Forest Glen Solar Farm (SSD-9451258)
Request for additional information

I refer to the Amendment Report and Response to Submissions for the Forest Glen Solar Farm. We require the additional information noted below:

Figure 1 Site access

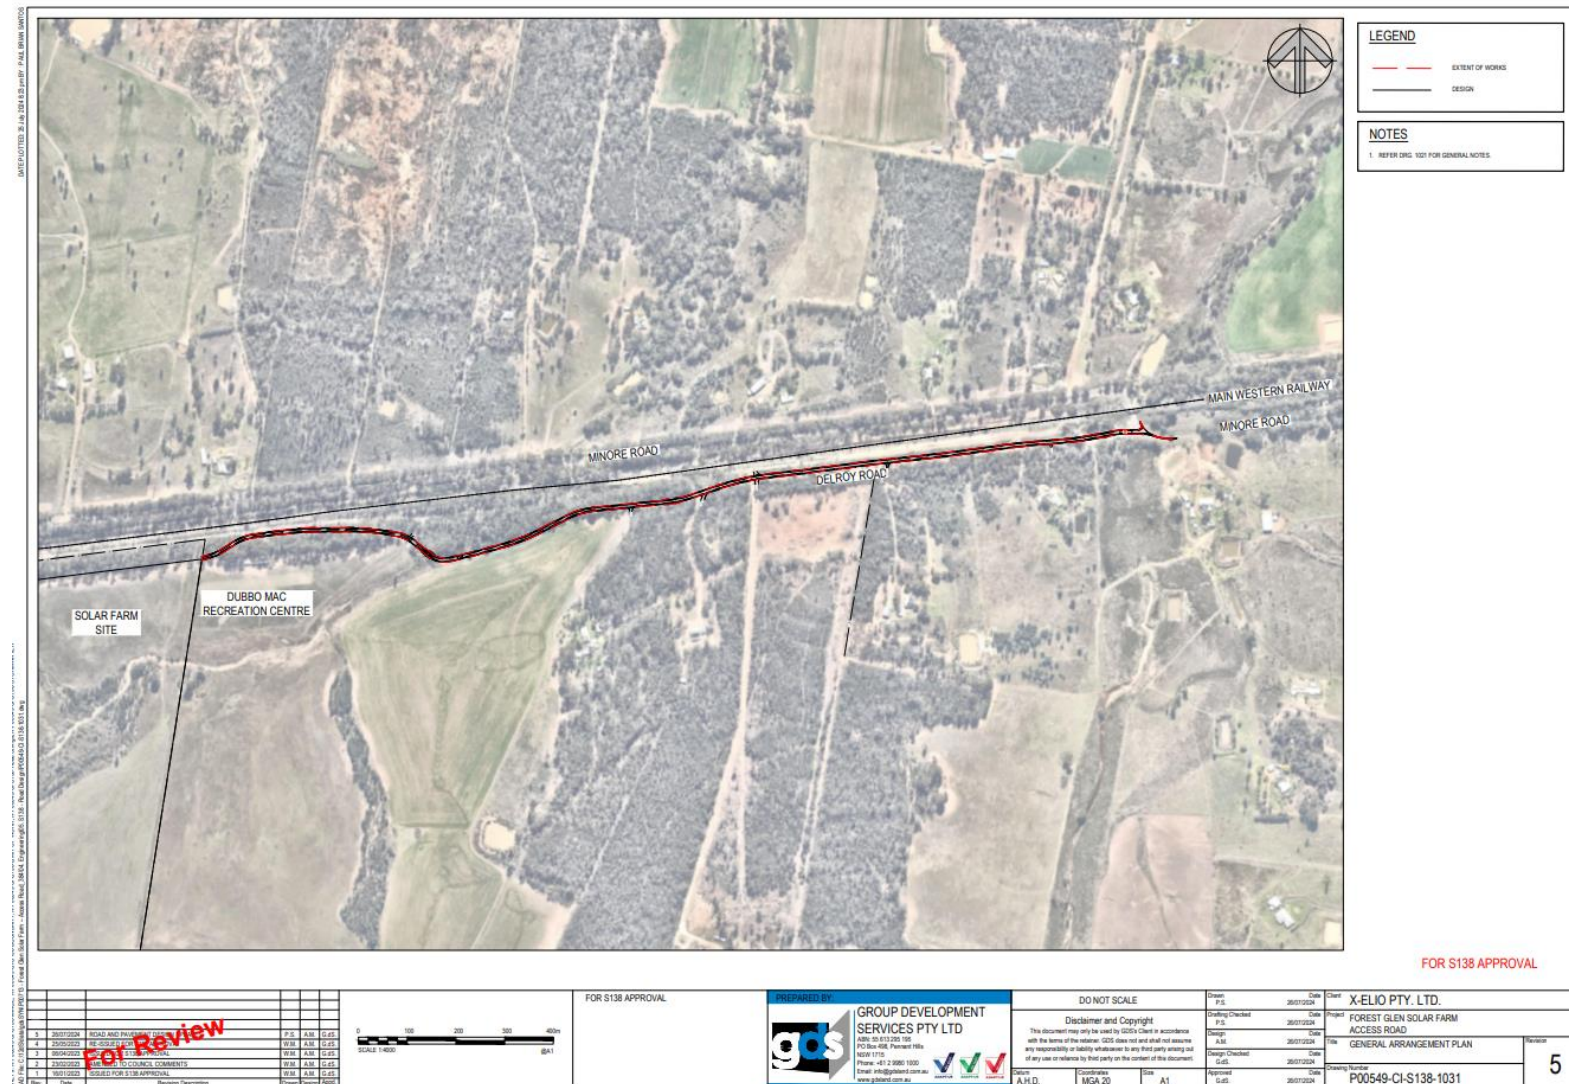
- confirm the proposed road upgrades and site access works and confirm:
 - road authority agreement to the works; and
 - actual extent (e.g. chainage) of proposed sealing works;
